**Application** H02-0511-25  
**Location** Land off Postland Road Crowland  
**Proposal** Proposed development of 9 Dwellings

**Name** Diane Gordon  
**Address** SHDC Environmental Protection

Plot 5 - House Type S503

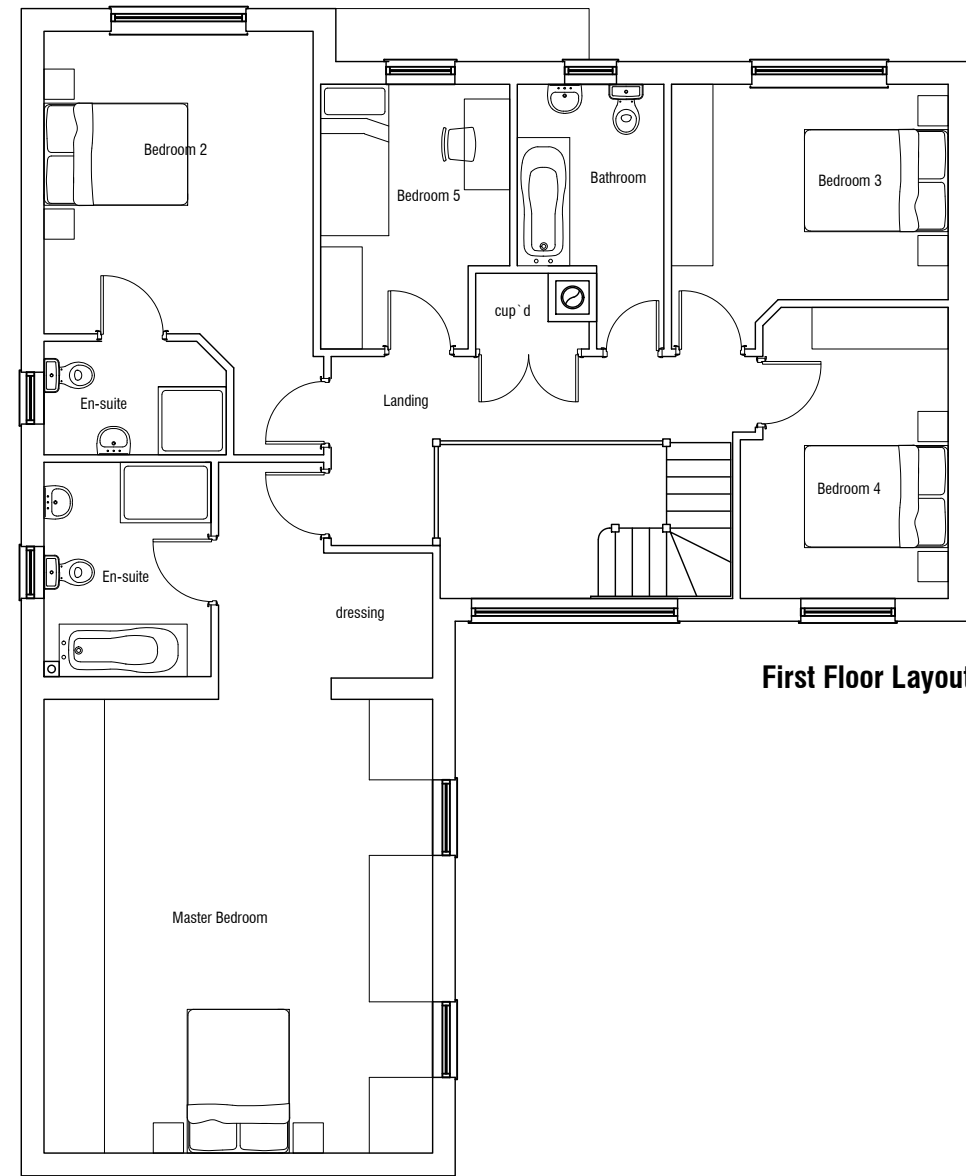
the noise impact assessment NIA 11796-24-12035-v2 makes recommendations regarding attenuation measures for plots 5 and 6. i would recommend that these are included within the specifications for enhanced glazing for the habitable rooms in plot 5 facing the current jj cars premises. boundary treatment to 5 and 6 should include a 2m accoustic grade fencing as opposed to the proposed 1.8m, in order to reduce any potential noise impact on these residential properties to an acceptable level
